Ribble Valley Borough Council

App no: 3.2026.0356

Address: Land at Hammond Ground Whalley Road Read

Proposal: Erection of 77 no dwellings and creation of community parkland, with vehicular access from Whalley Road and associated infrastructure, parking and landscaping.

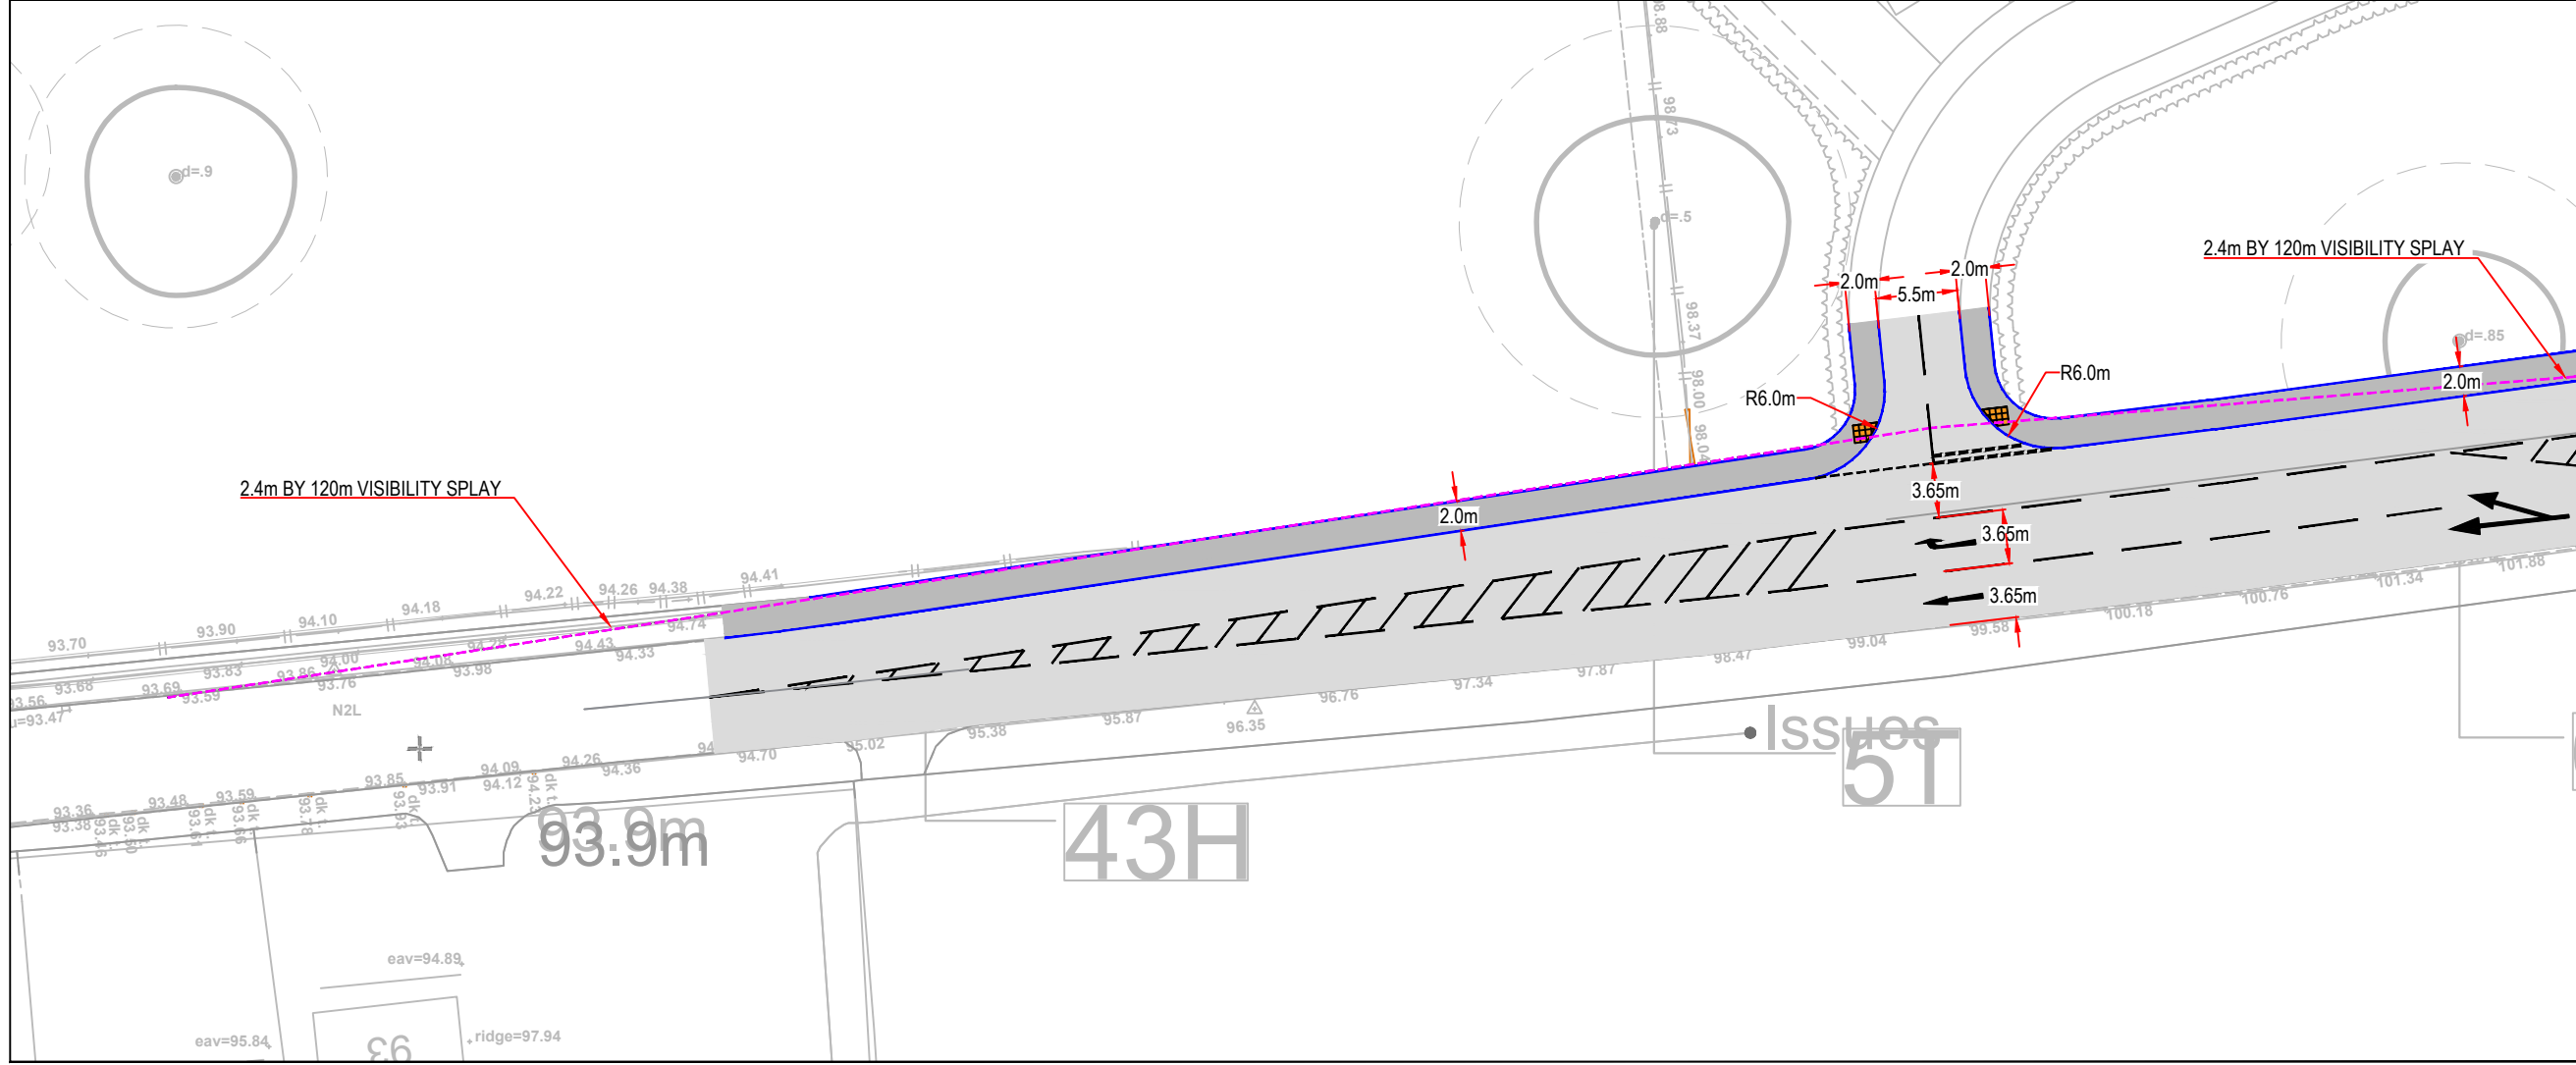
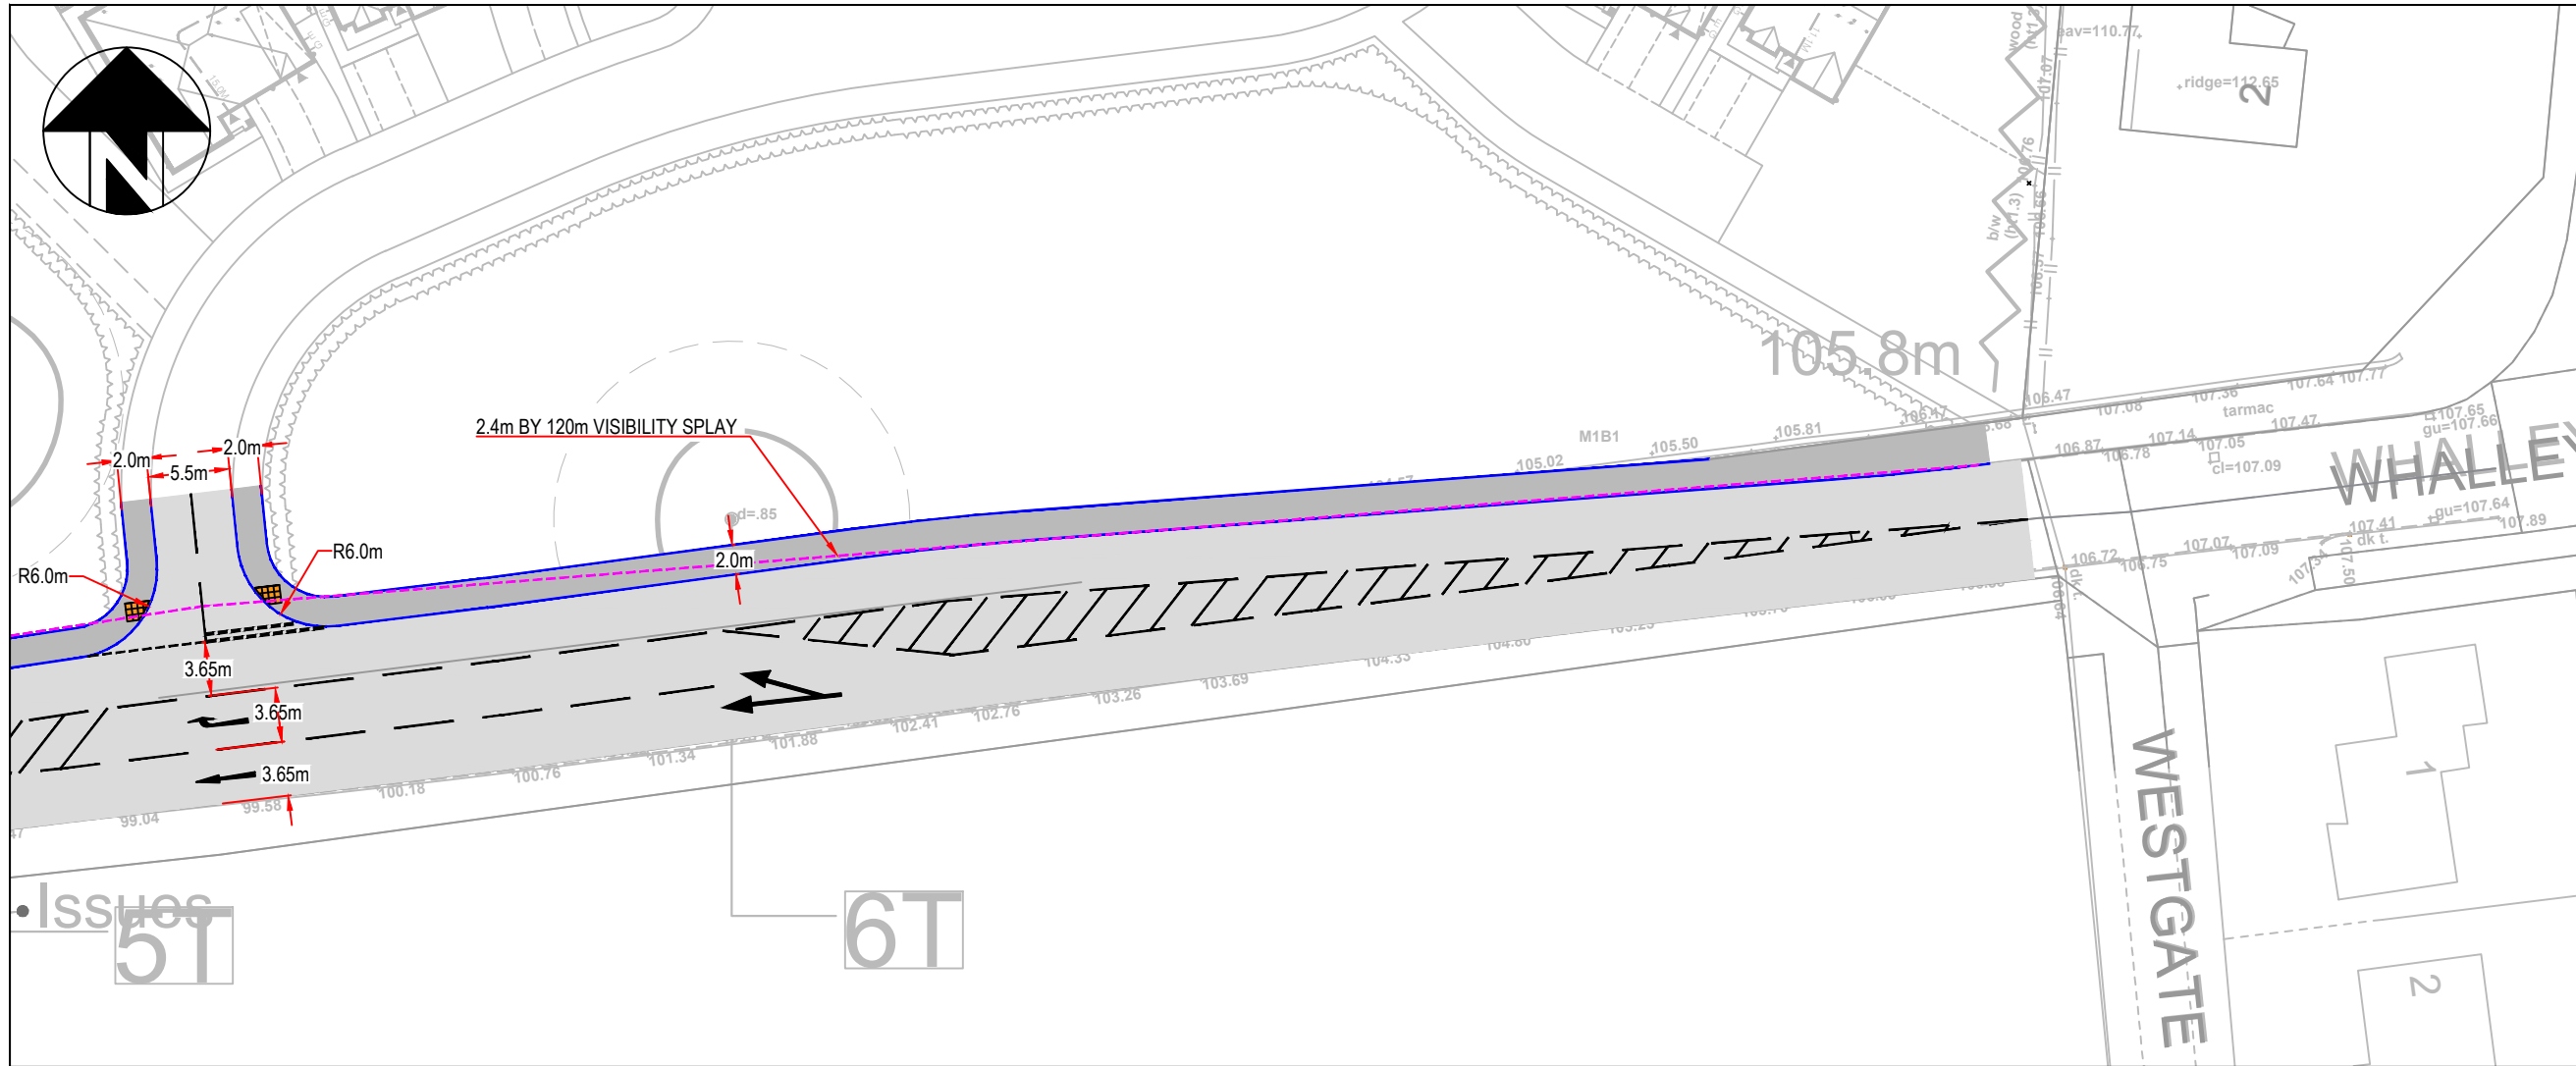
Swept path analysis has been conducted for a standard 11.125m standard refuse vehicle at the access and the internal layout. The widened access width will reduce the impact upon larger vehicles crossing onto the opposing traffic lane when turning.

AMA-22655-SK001.1

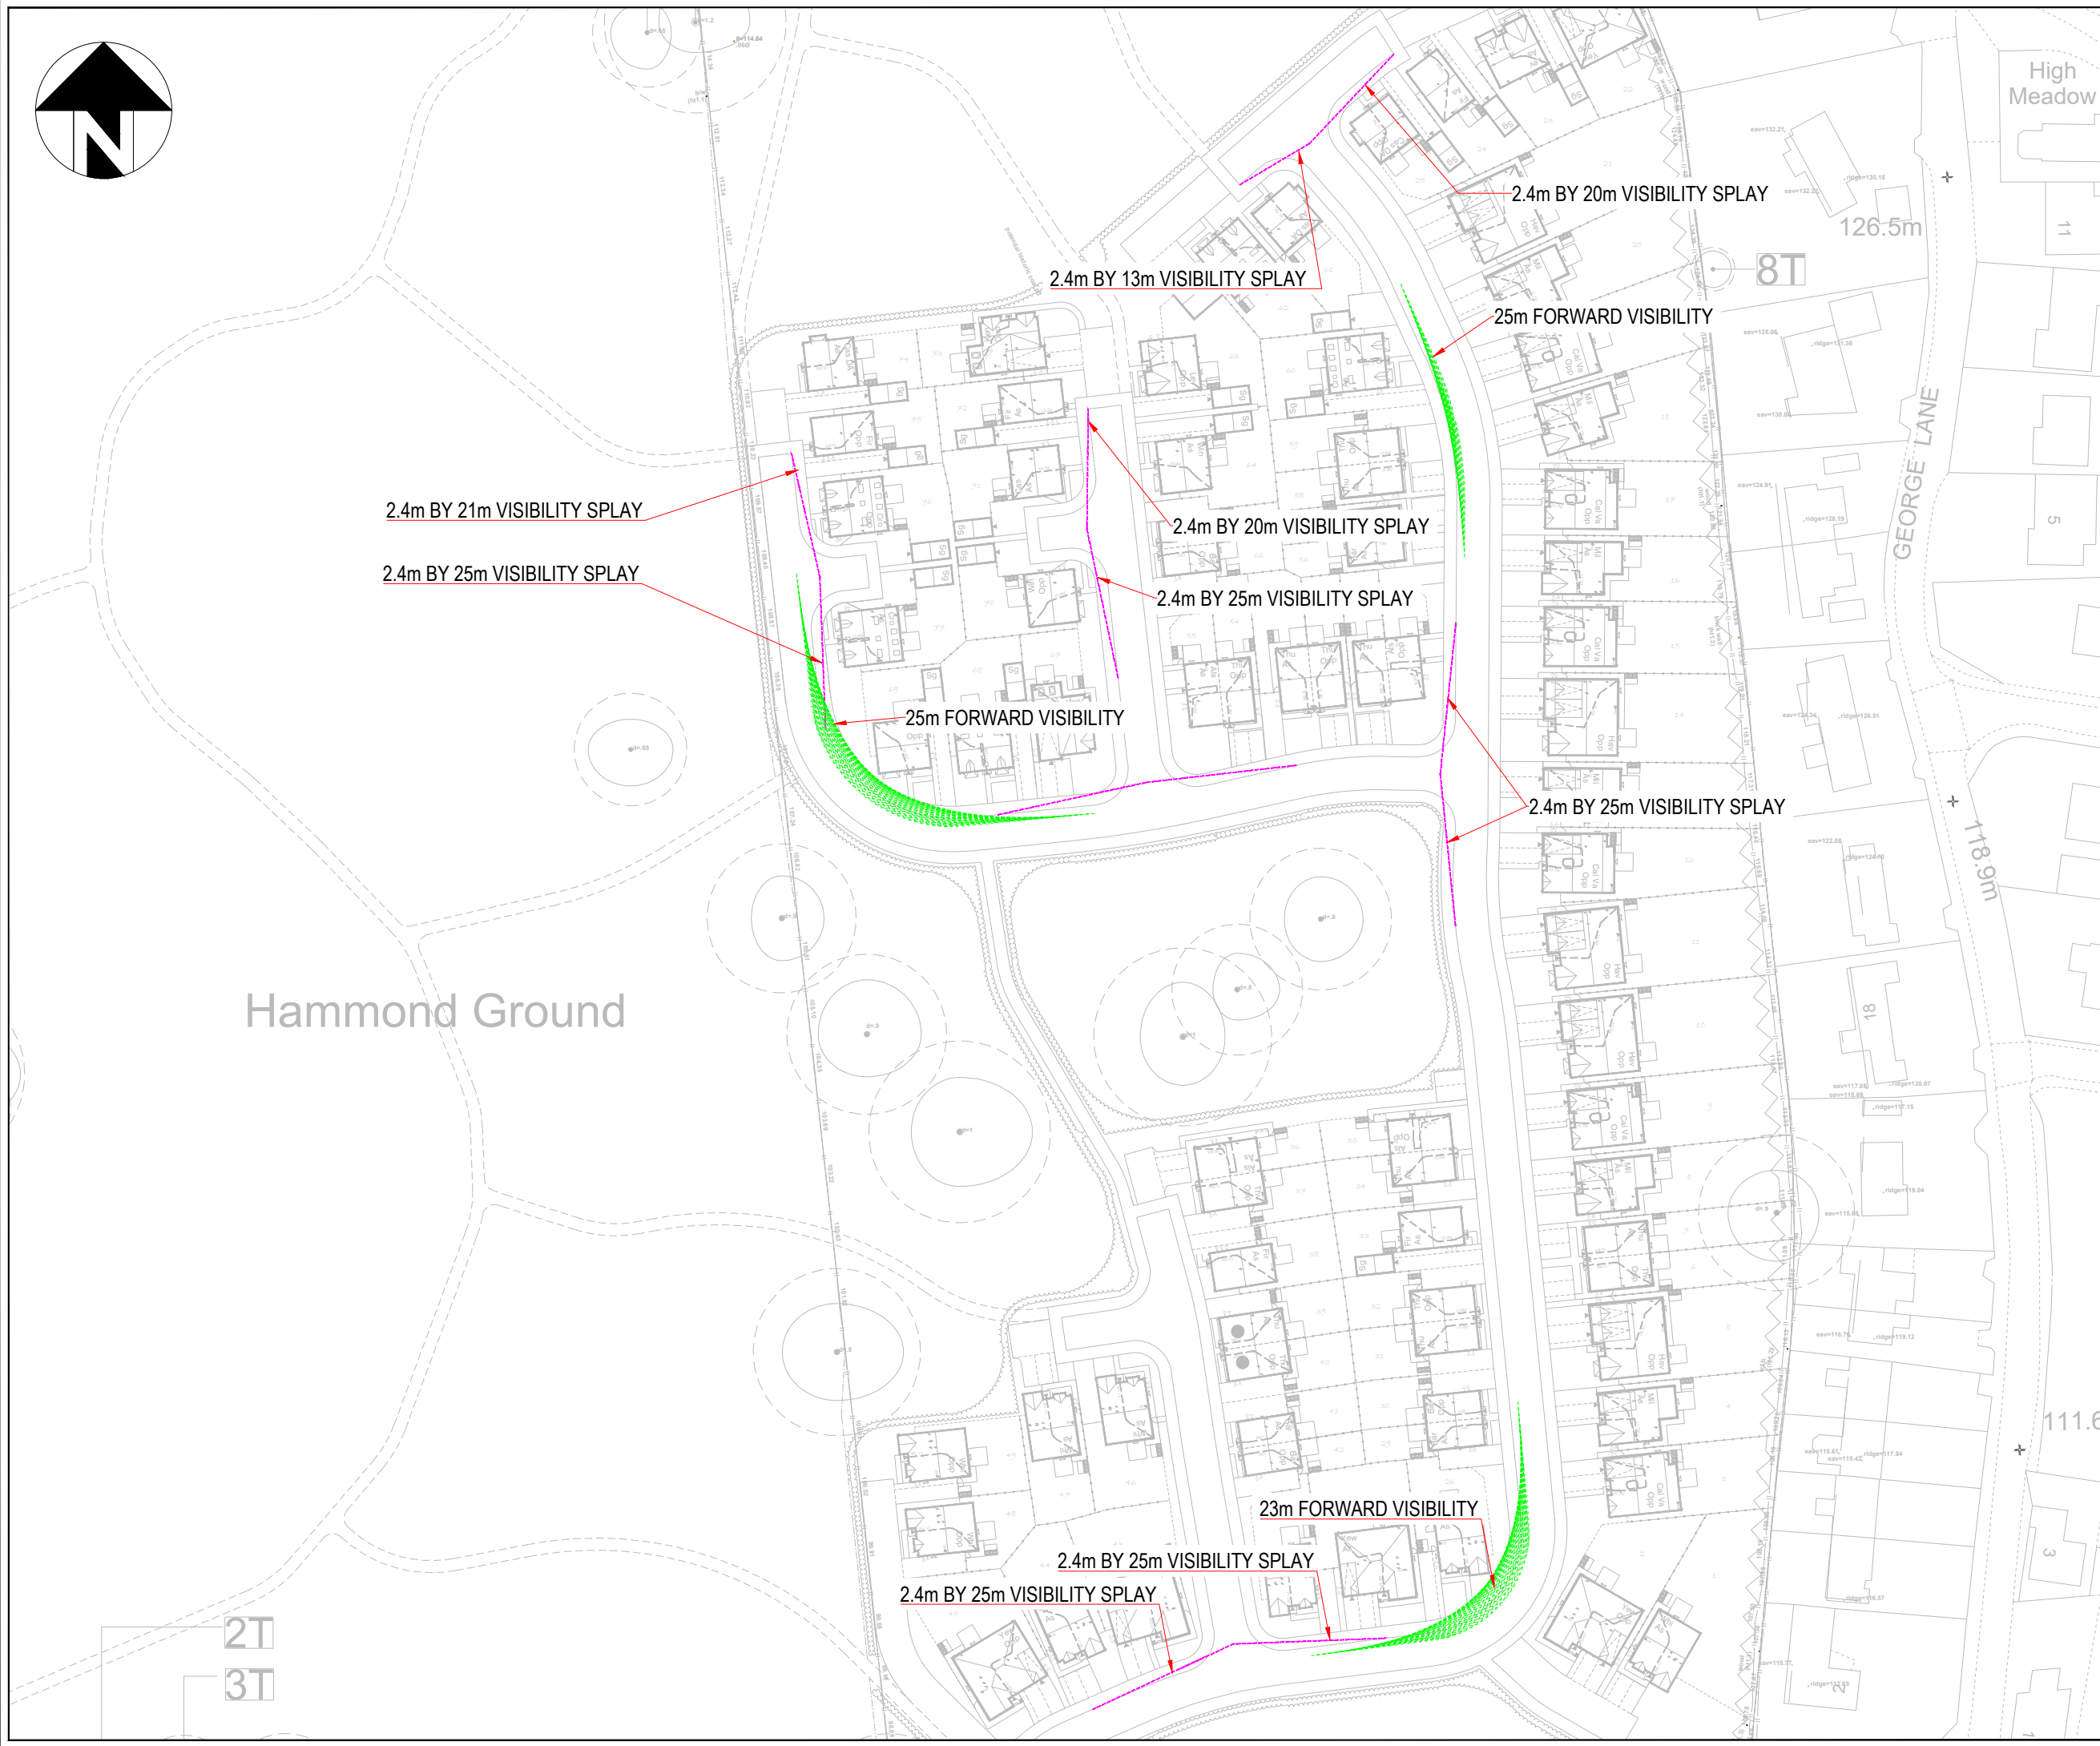
Visibility splays of 2.4m by 120m to both sides are shown on the site access arrangement which accords with the Design Manual for Roads and Bridges (DMRB) standards for a 40mph speed limit.

We would request that the results of the 7-day ATC which was undertaken in September 2025 on Whalley Road are submitted and summarised to show the 85thile speeds in both directions at the site access. We would request that the visibility splays are provided in accordance with the recorded 85thile speeds.

The new site access is proposed as a priority junction with right turn ghost lanes. We would request that this is amended to provide central islands to both sides of the right turn lane for highway safety and to promote speed compliance.

As stated above the signalised crossing and new bus stops will need to be incorporated into the site access design together with a widened footway along the frontage of the site to create a shared cycle/footway of 3.5m.

The first section of the site access carriageway must be widened to 6.5m to the first internal junction of the estate.
